**Our ref:** WA/2015/120640/08-L01  
**Int. Party ID:** 10031668  
**Your ref:** TR010019  
**Date:** 06 January 2016

**Deadline 5 (8 Jan 2016) - Response to the Examining Authority's (ExA) 2<sup>nd</sup> written questions  
Development Consent Order Application M4 - Junctions 3-12 (Smart Motorway)**

**M4 JUNCTIONS 3 TO 12 SMART MOTORWAY**

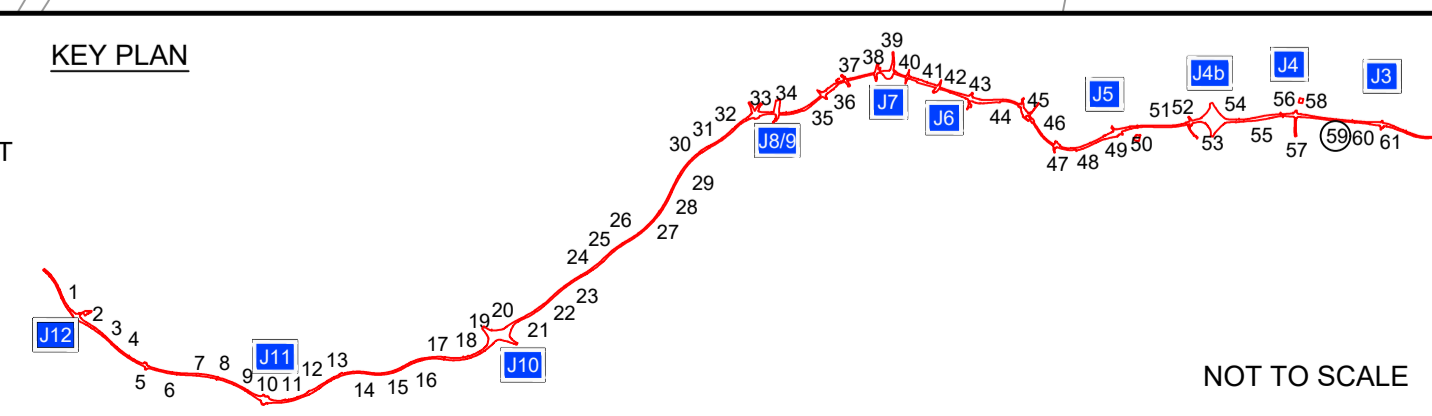
3.16 It is agreed that there will be no culverting or diversion of Frog's Ditch to accommodate ERA E1-A1 shown on Sheet 59 of the General Arrangement Drawings (Annex F1 to the EDR) (Application Document Reference 7.4). This drawing will be updated before the end of the Examination.
